COUNTY OF HARNETT LAND USE APPLICATION

PINE GROVE DEVELOPMENT CORP.
LOT #49
NATURES CROSSROADS, PHASE TWO
0.51 ACRES

**Re: Status of Improvement Permit Application #07-5-17558
Nature's Crossroads Lt 49**

**SWEETBAY PLACE
50' PUBLIC R/W**

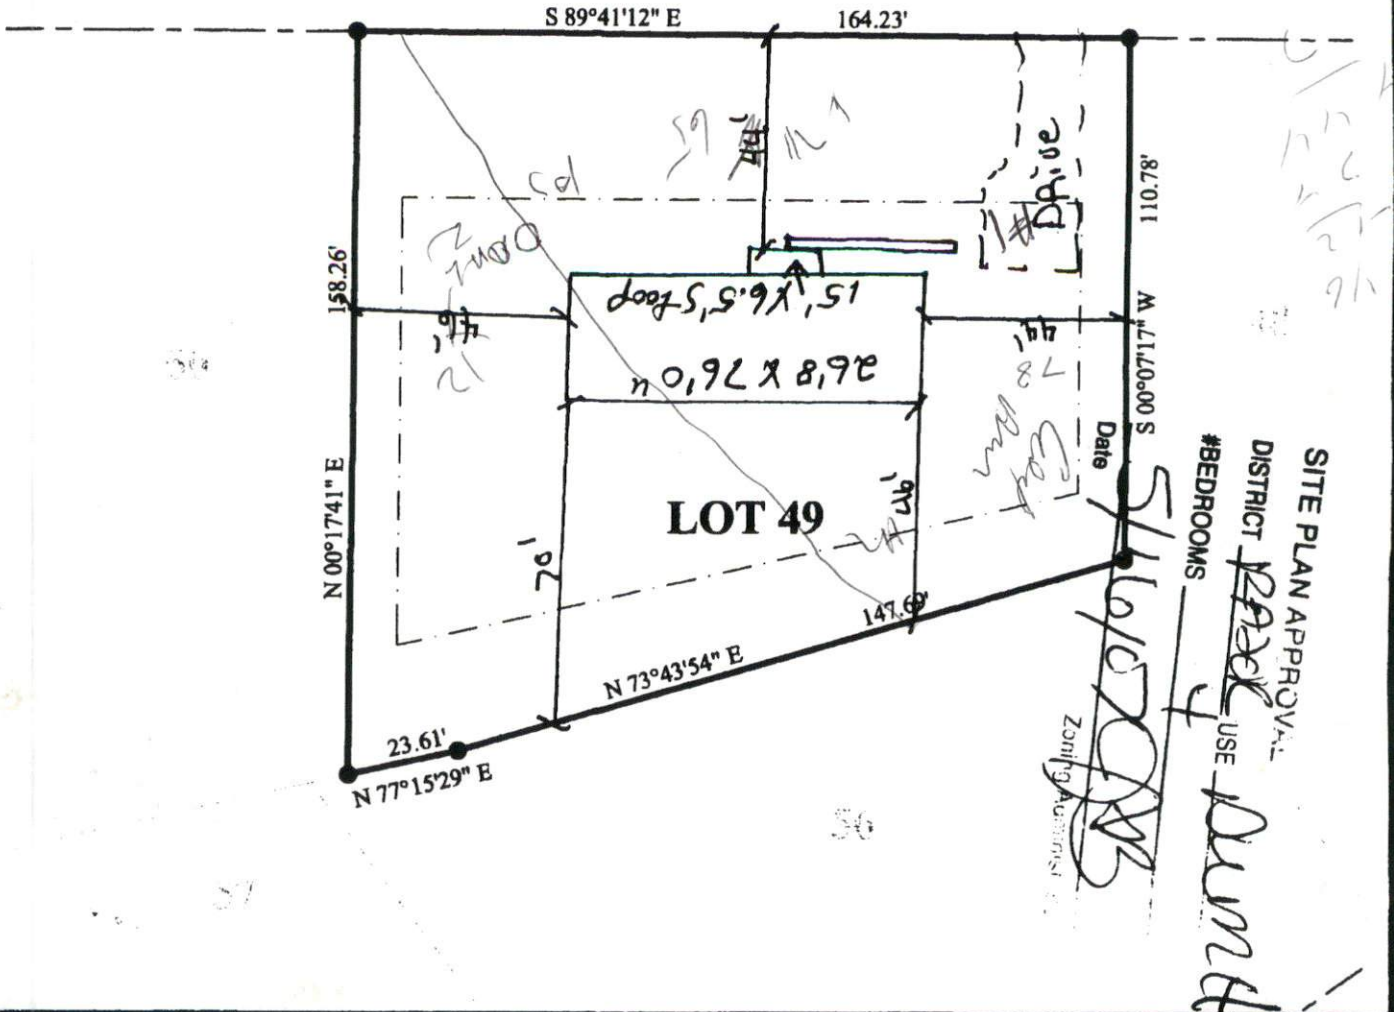
- 1. Property lines/corners not marked or labeled
- 2. House corners not marked or labeled
- 3. Directions not clear to property
- 4. Property needs brush or vegetation removed
- 5. Backhoe pits required
- 6. Other – **Move house as shown on attached sheet and reduce the number of bedrooms to 3. You will need to revise your application and submit new plot plan to Central Permitting and reconfirm, before I can issue any permit.**
